DOC17/503496

SSI 7485

EIS for WestConnex M4-M5 Link SSI 7485 - Request for EPA Comment

Figure 26-2 Cumulative construction impacts - Haberfield (Option A)

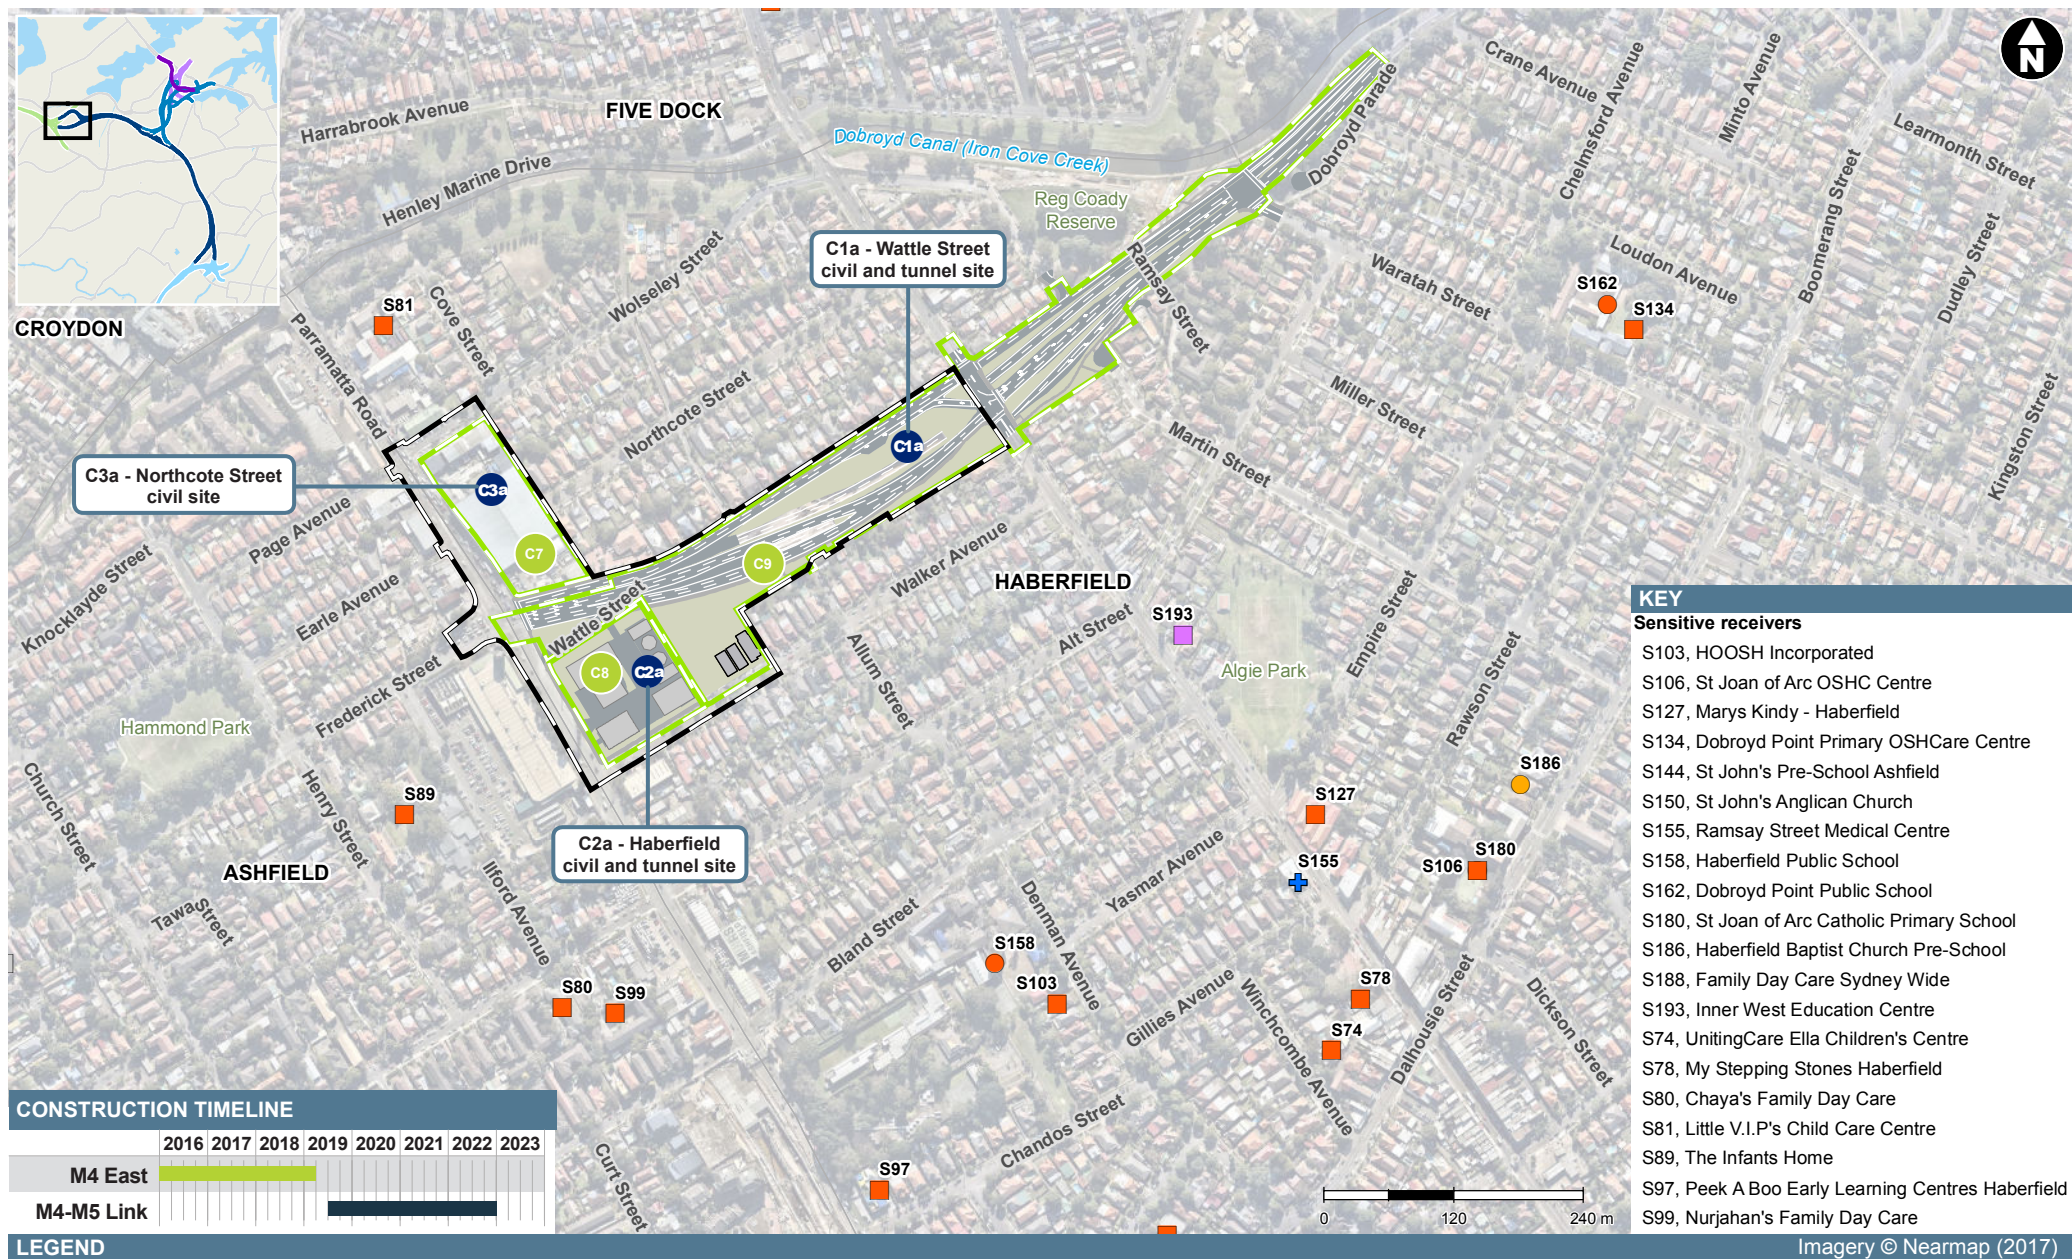
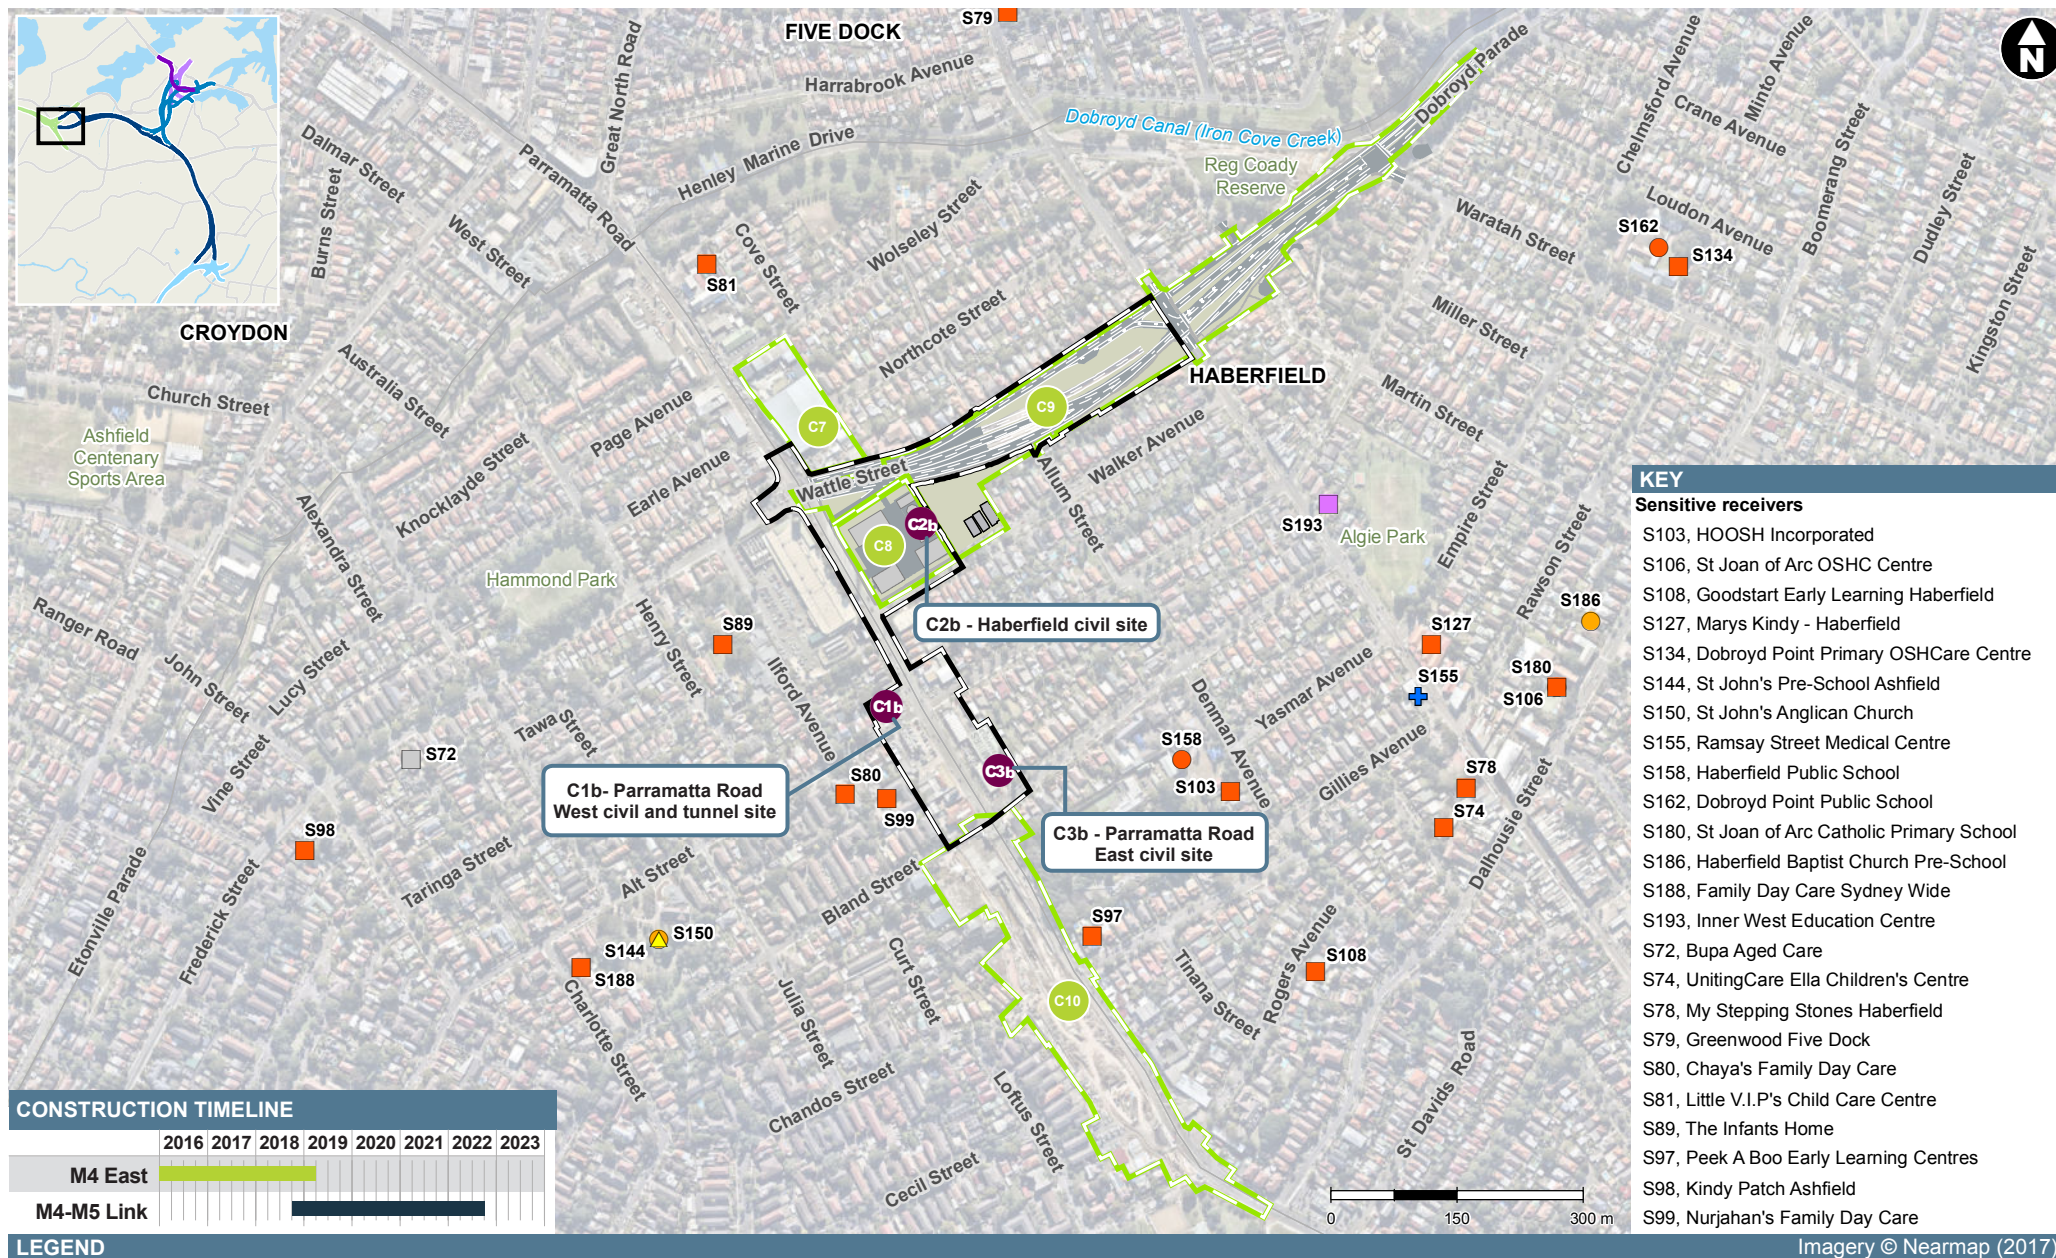
- 3.1.1 The EIS includes discussion of options A and B for tunnelling and support works at Haberfield. This indicates that noise and vibration mitigation is conceptual at this point and that further

Recommendation: Further assessment of actual impacts and reasonable and feasible mitigation measures is undertaken.
